# Rezoning Transportation Analysis

Petition Number: 2024-018

Date	Description
03-27-24	First Review (KC)
04-24-24	Second Review (KC)
05-29-24	Third Review ZC (IW)

# RZ-1.0

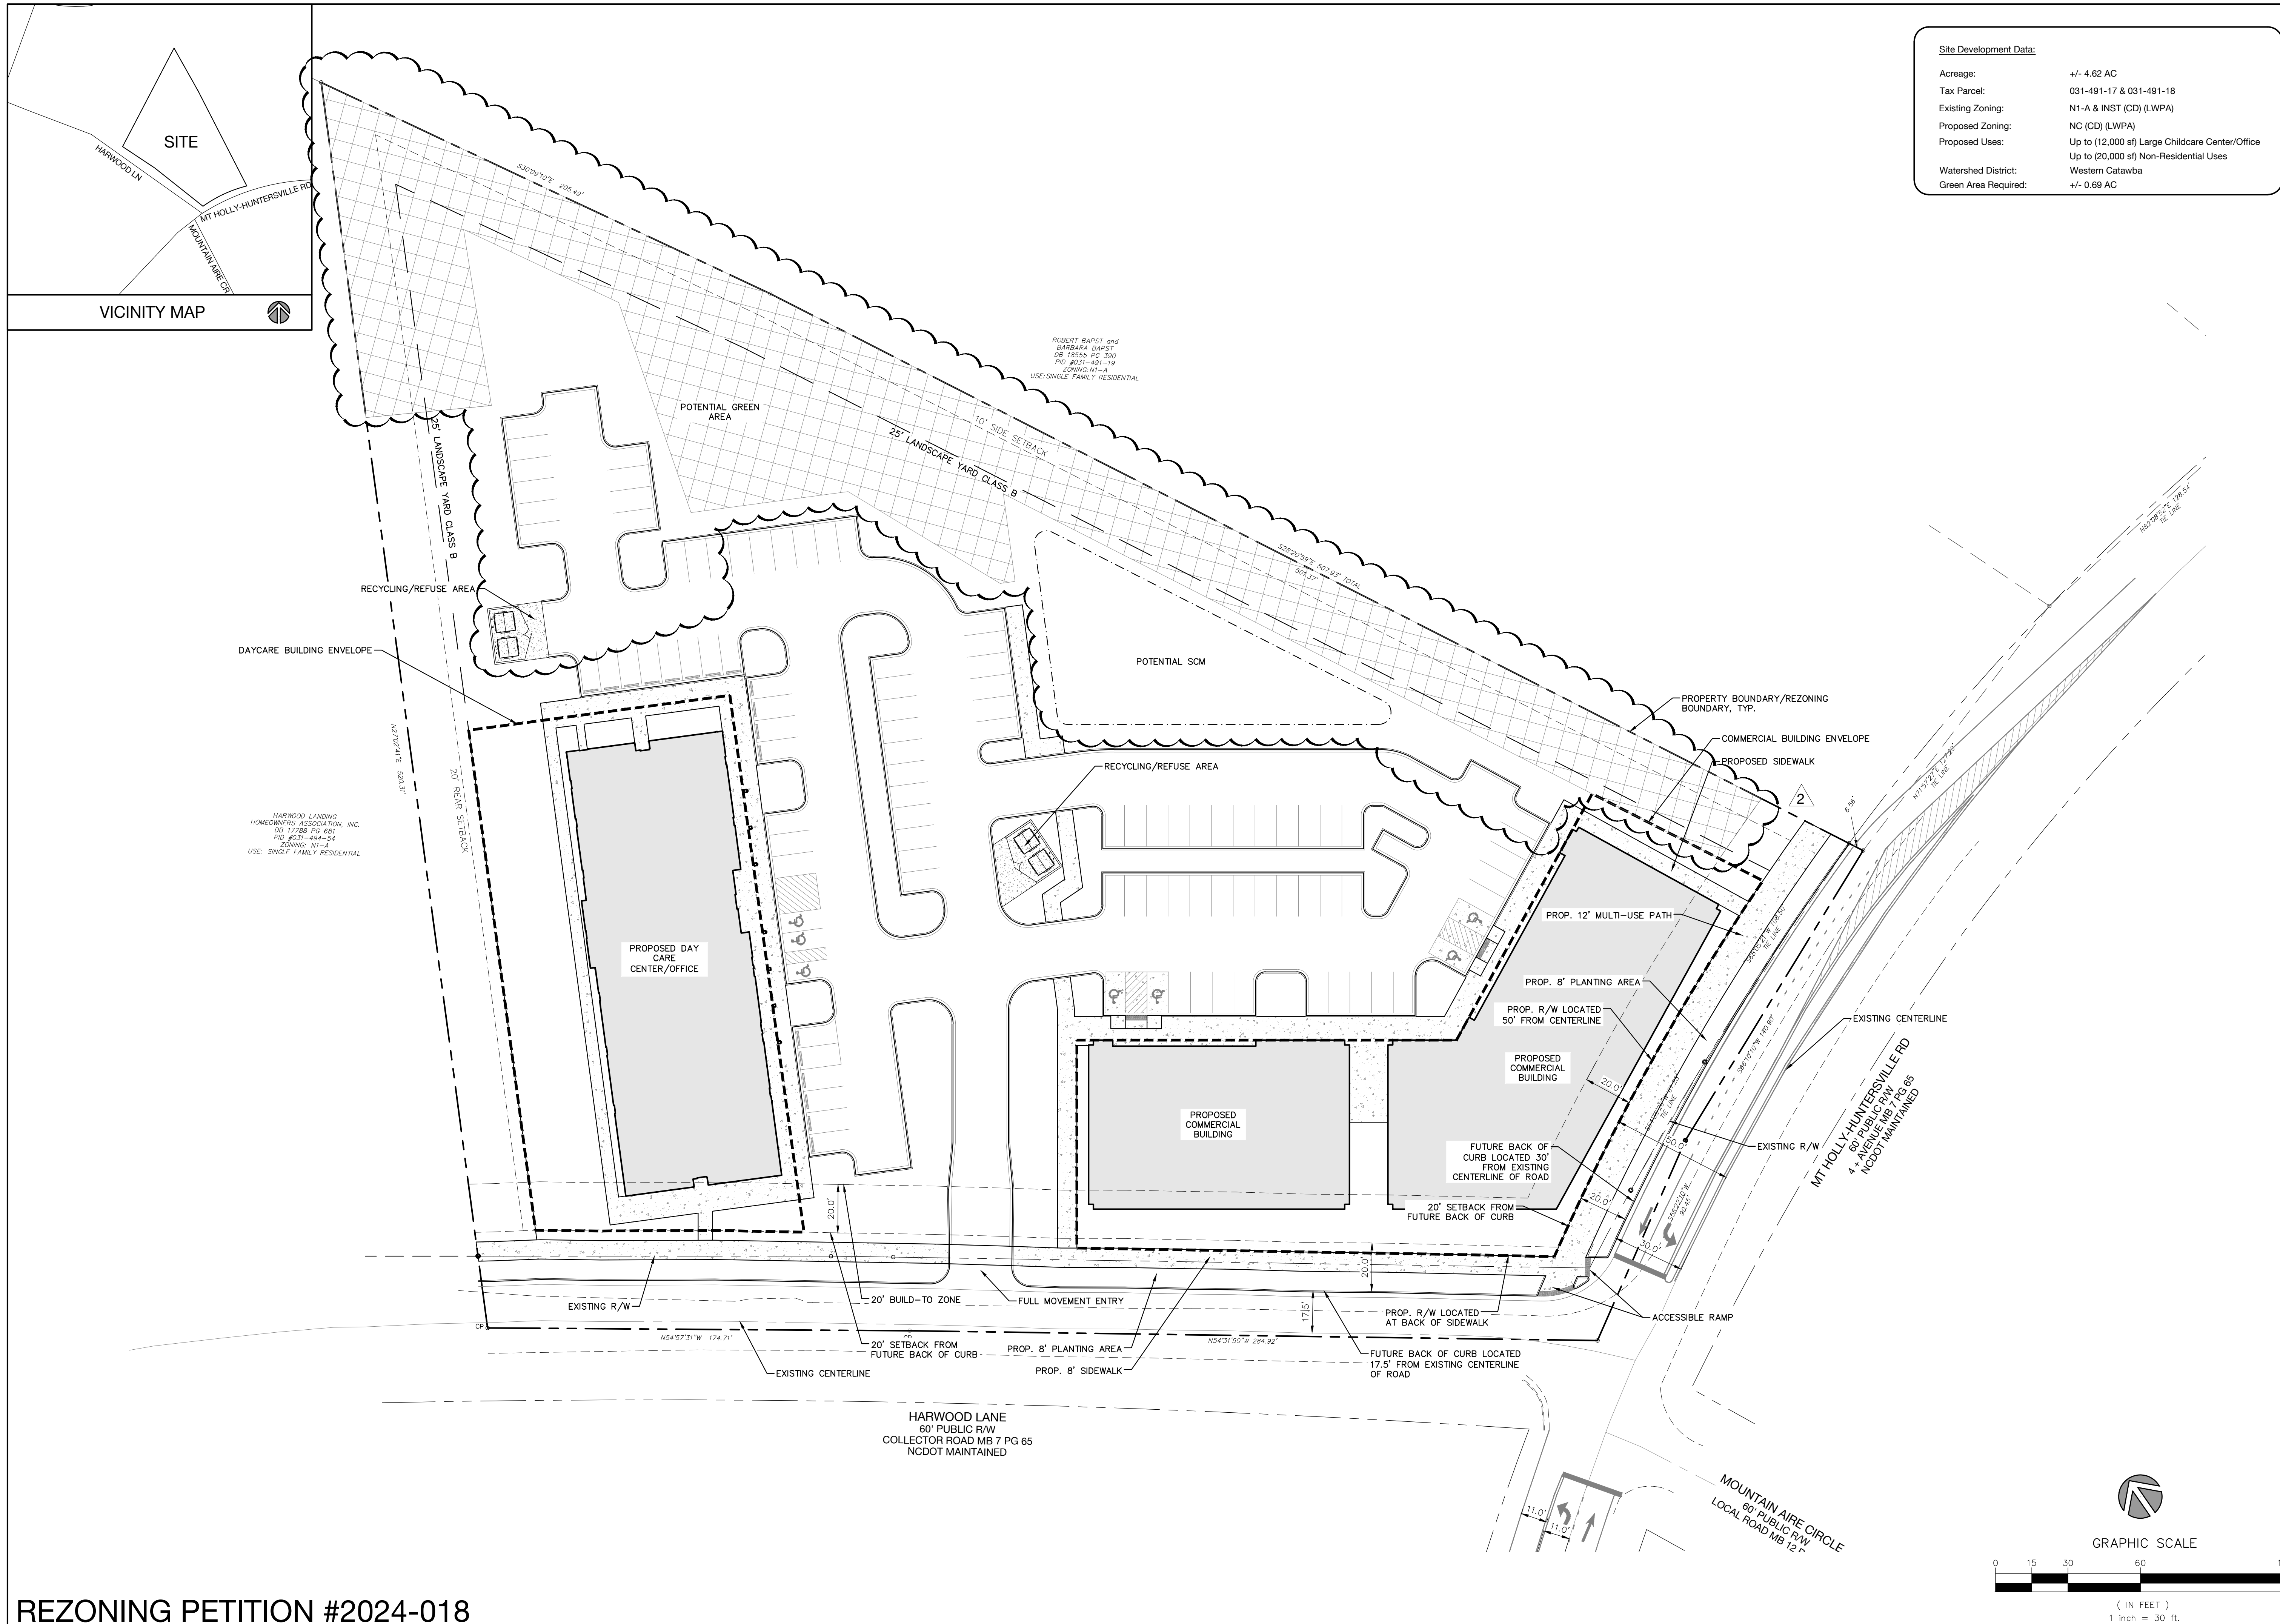
a. ~~Mt Holly Huntersville Rd:~~ The future location of curb and gutter is 30' from centerline.

b. ~~Harwood Lane:~~ The future location of curb and gutter is 17.5' from centerline.

~~Label and dimension the curb and gutter from the centerline for each road on the site plan. Show proposed striping layout for Mt Holly Huntersville Road and commit to restriping for left turn lane on Mt Holly Huntersville Road at Harwood Lane.~~

RZ-1.0

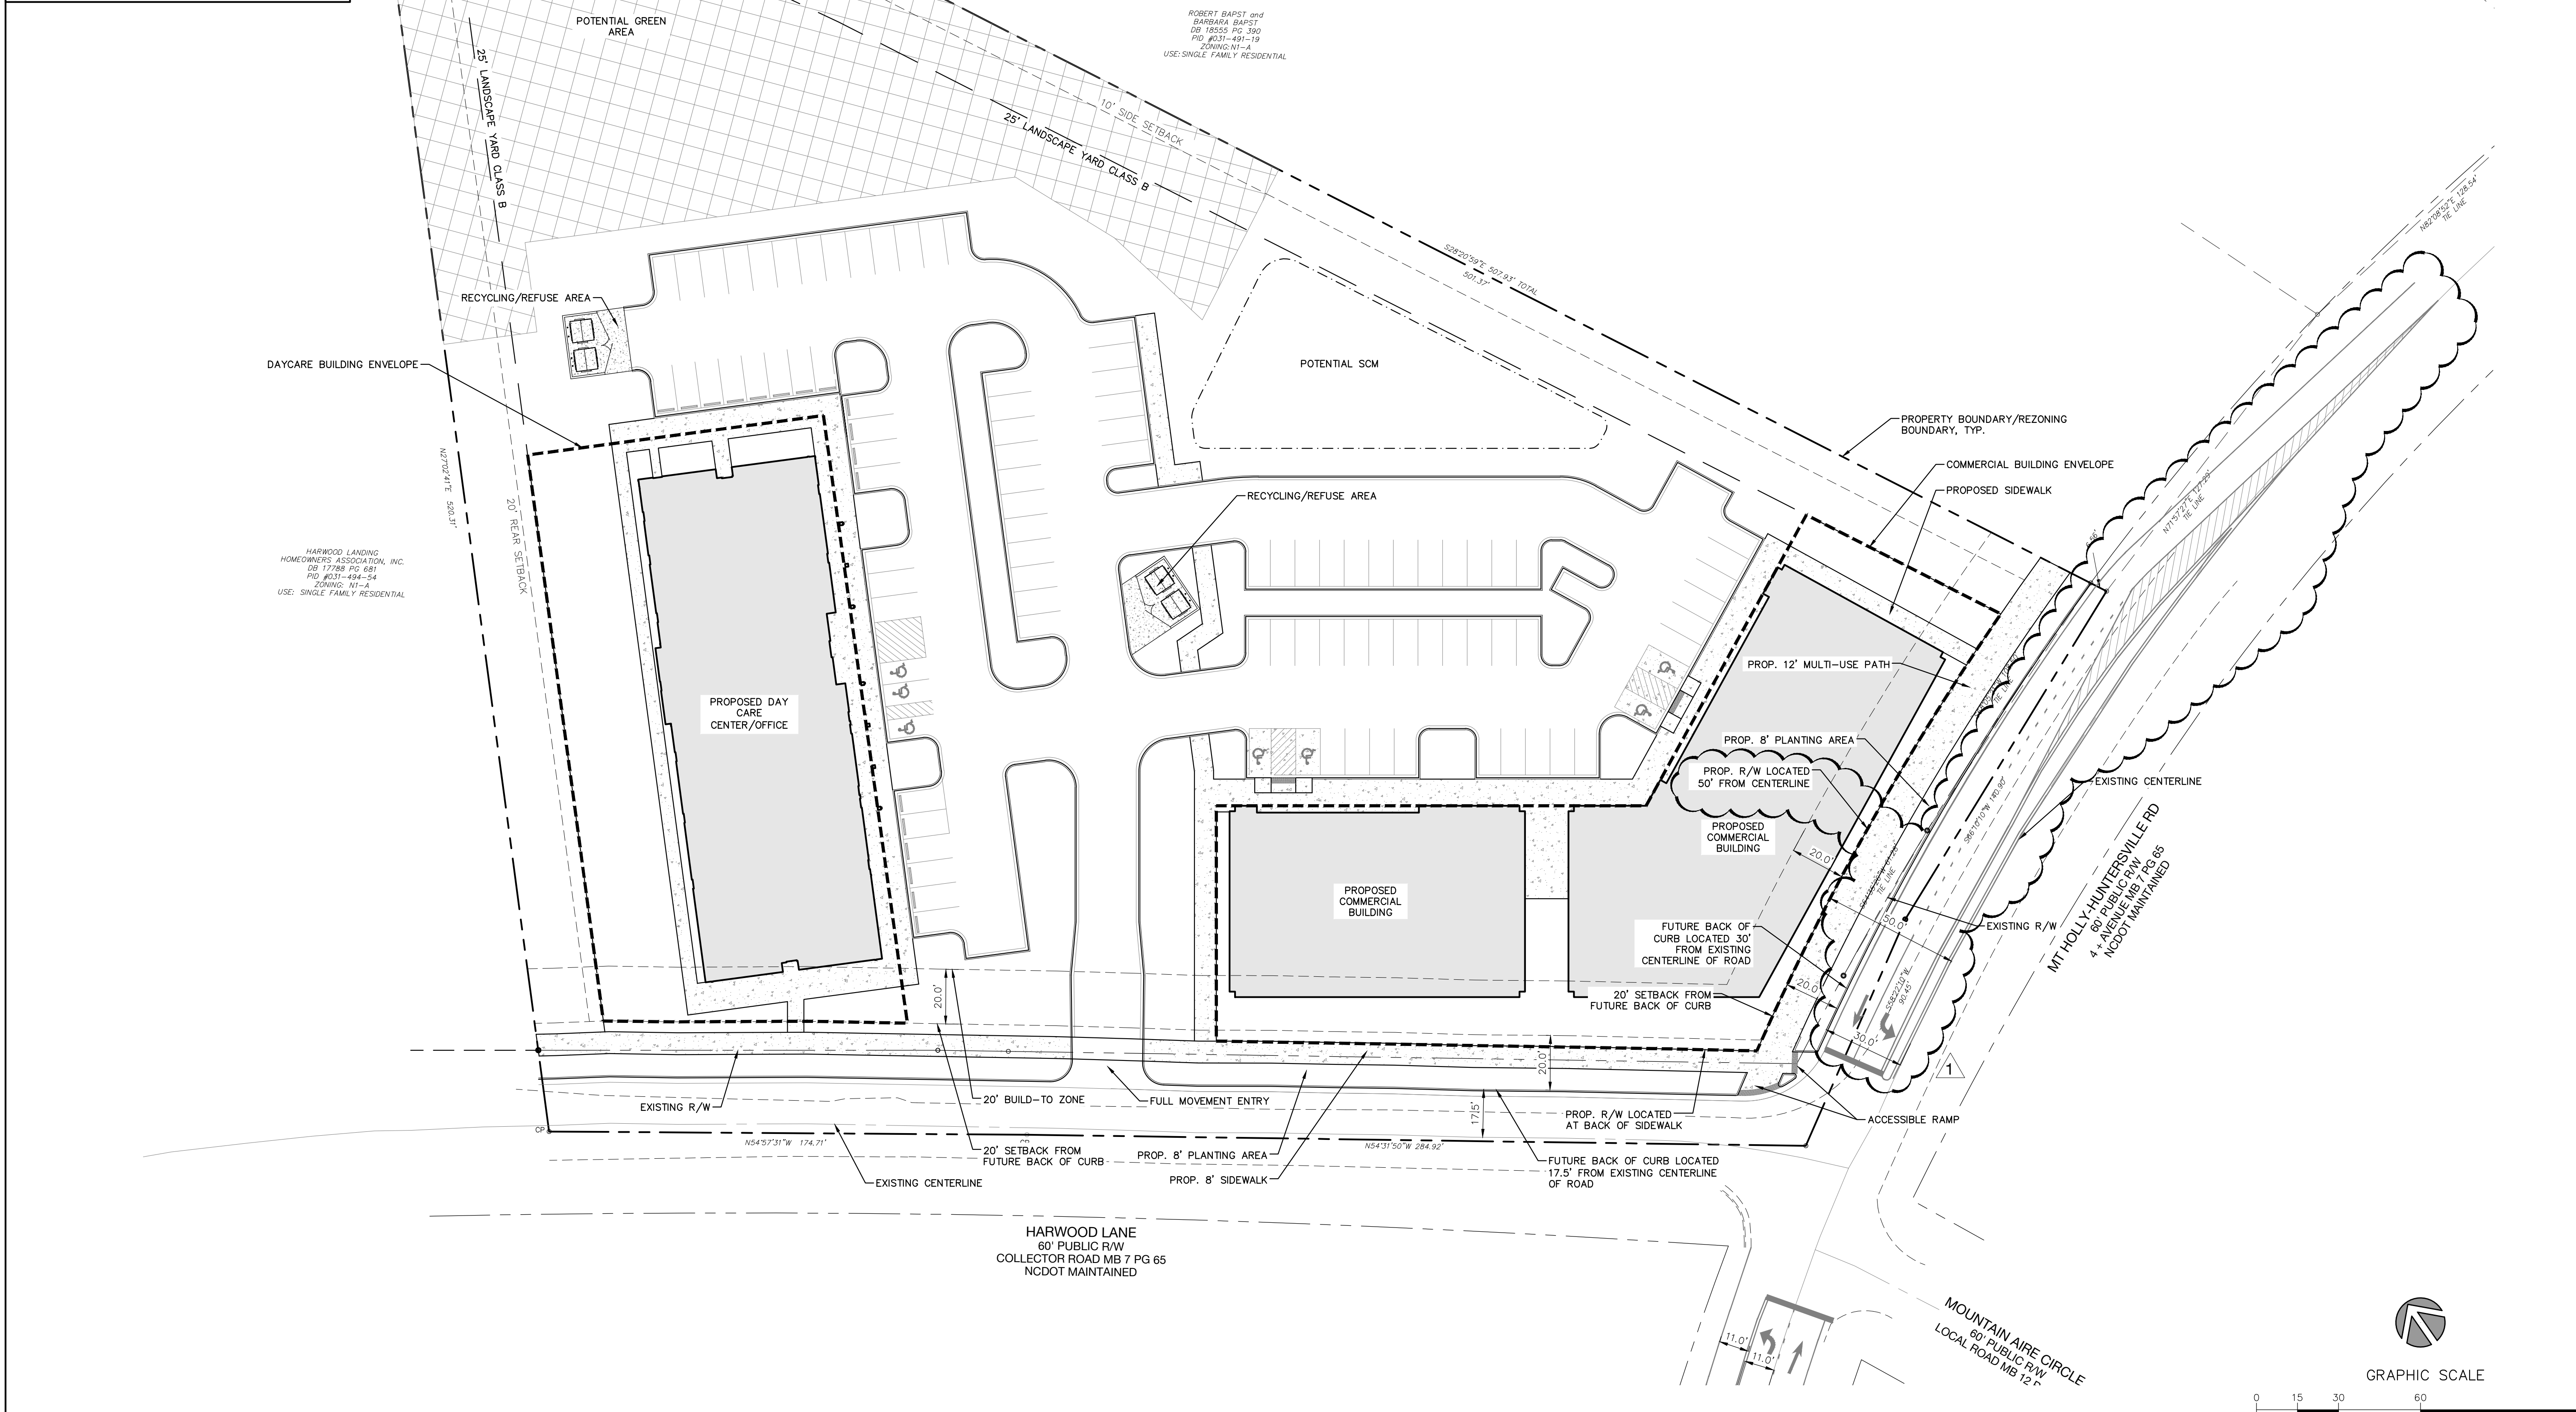
~~**04-24-24 Outstanding Comment:** Revise CTR summary table. The solid waste internal to the site is not by location and just 14 points for having it internal for the whole site. Additionally, we can only give credit for the SUP along Mt. Holly Huntersville. Looks like there is approximately about 215 feet of SUP along Mt. Holly Huntersville.~~

~~Frontage sidewalk that would be required by the ordinance otherwise does not count towards the multimodal mitigation points unless its physical improvements for bicycle or transit modes required by the UDO.~~
